Please upload the email below which is a further consultation response from **ADC Drainage Engineers** to discharge of condition application **LU/90/20/DOC** – Hampton Park.

Paul Cann
Principal Engineer (Drainage)

Hydro-Brake Control Chamber HB2

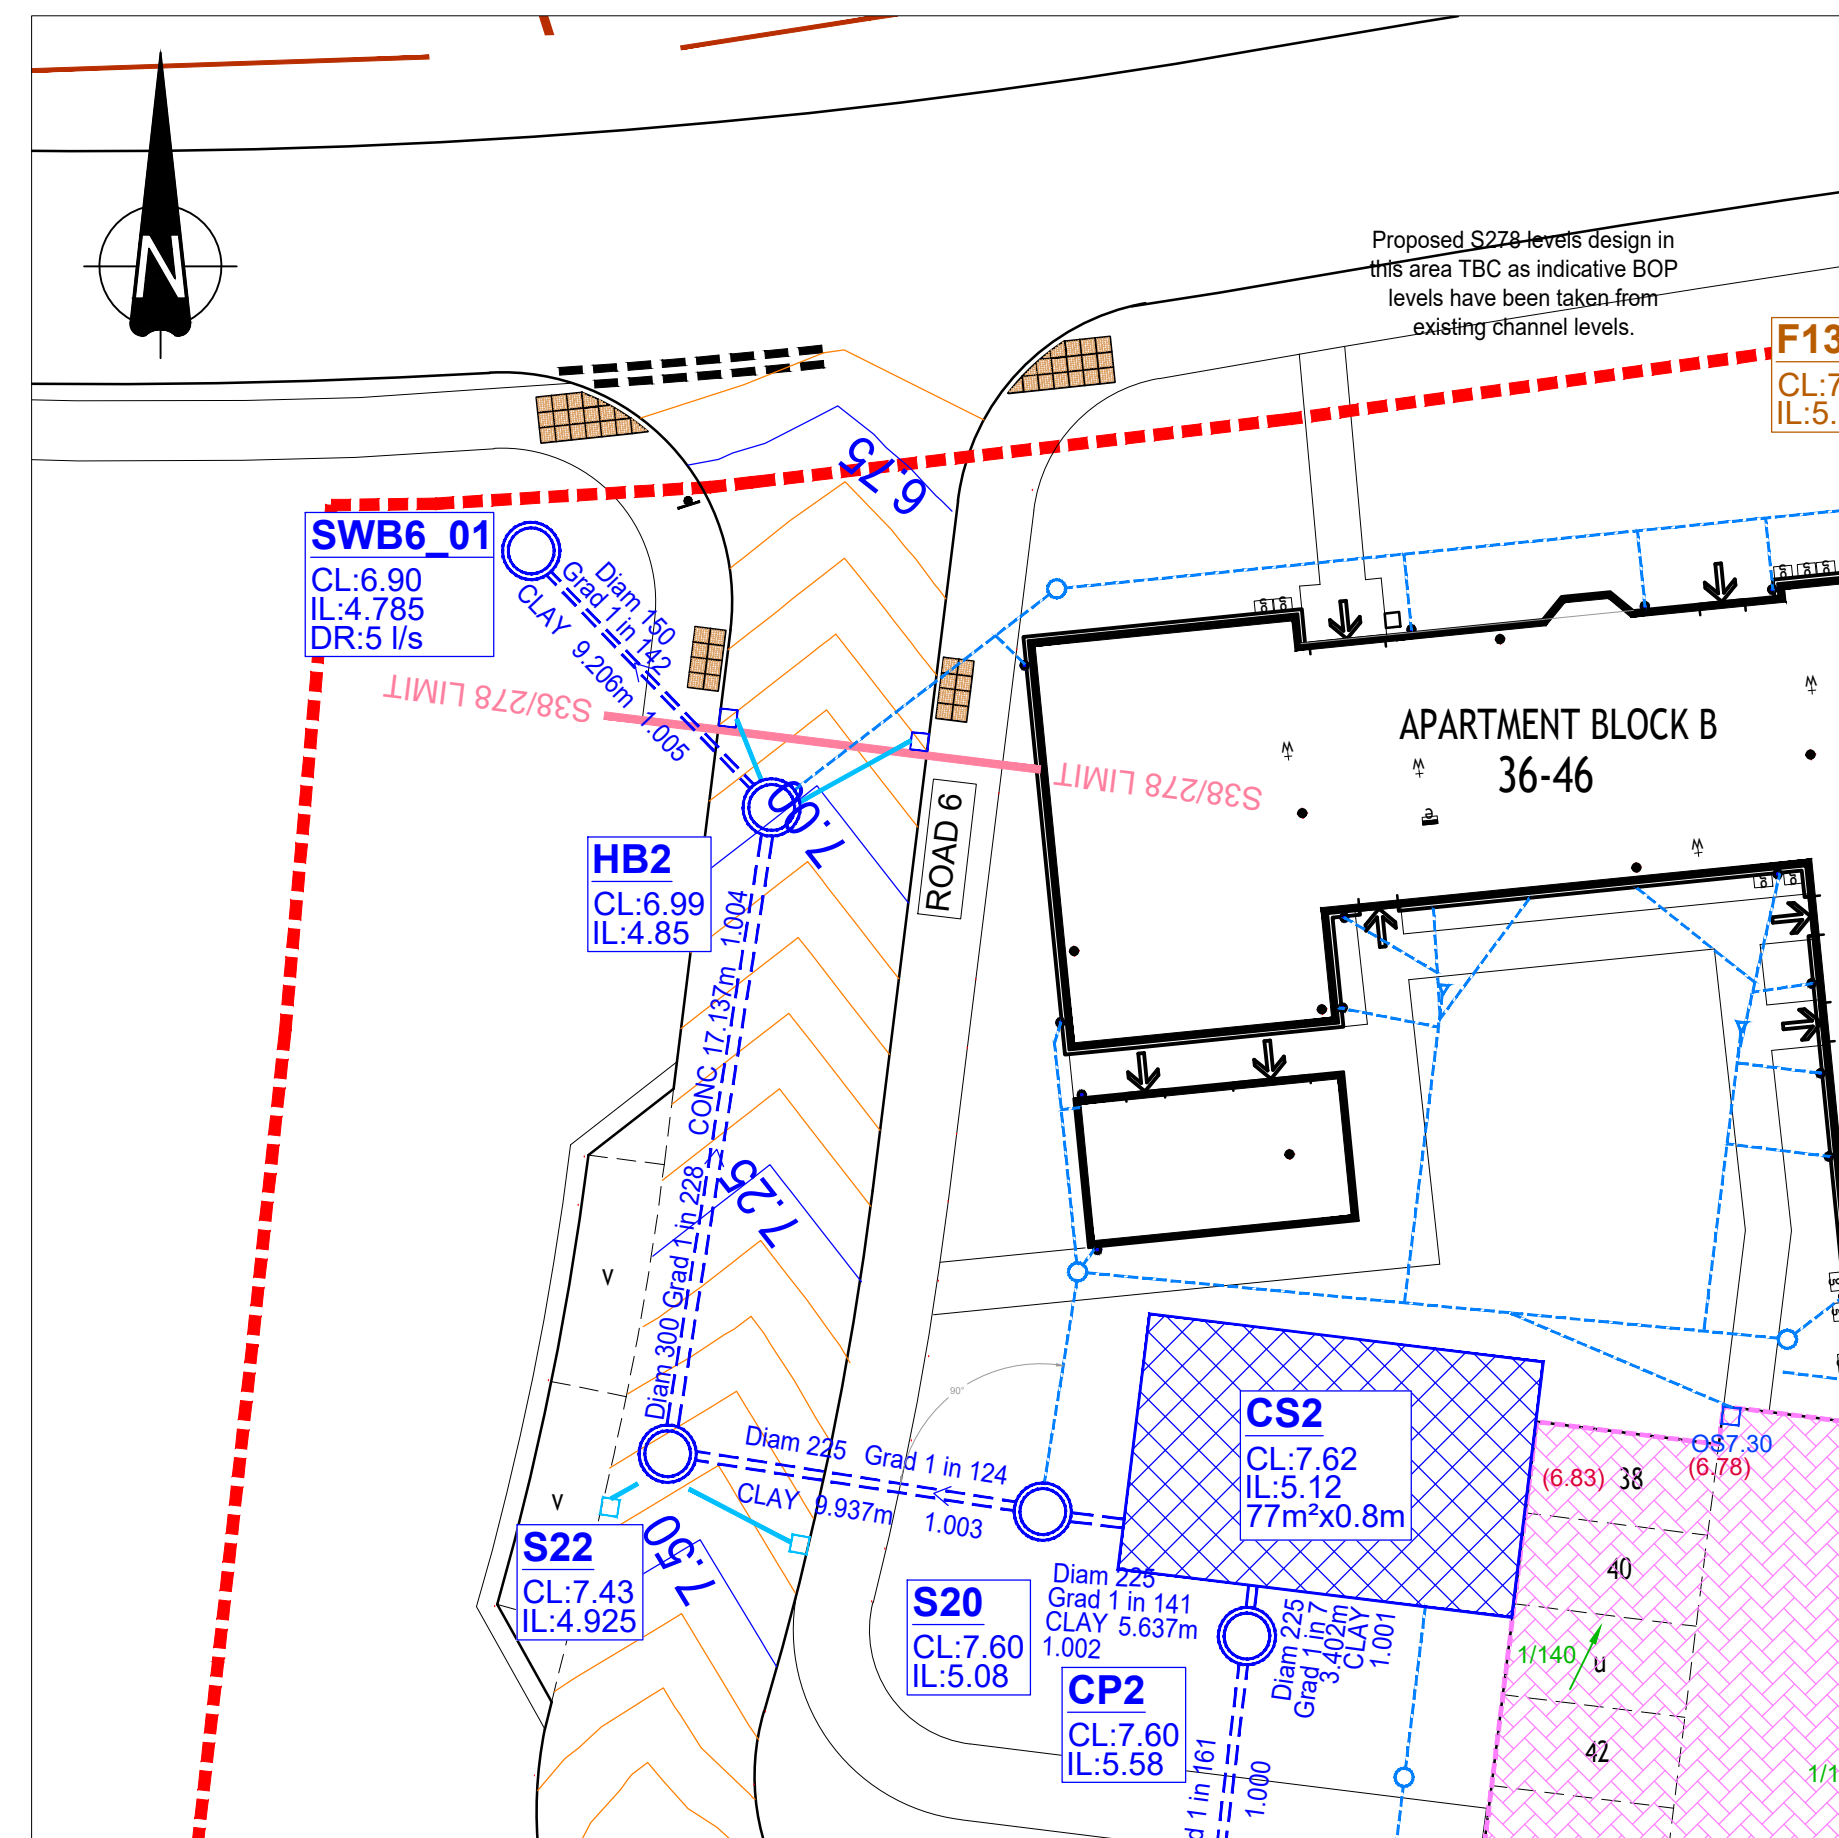
5. Hydrobrake chamber HB02 construction detail – plan view shows incoming 900mm pipe as opposed to 300mm and 1.8m dia rings as opposed to 1.5 dia. Incoming 150mm connections to connect soffit to soffit with 300mm pipe. The gully that is connecting against flow and above hydrobrake is not ideal but willing to accept it in this instance (Section A-A shows it in a different location to the plan view?)

6. Both hydrobrake chambers – show base thickness/reinforcement details.
7. Existing manhole SW03A – just upstream of SWA2_01 – what is its purpose? Invert level is lower than the downstream manhole. Please clarify if it is required and adjust as necessary.
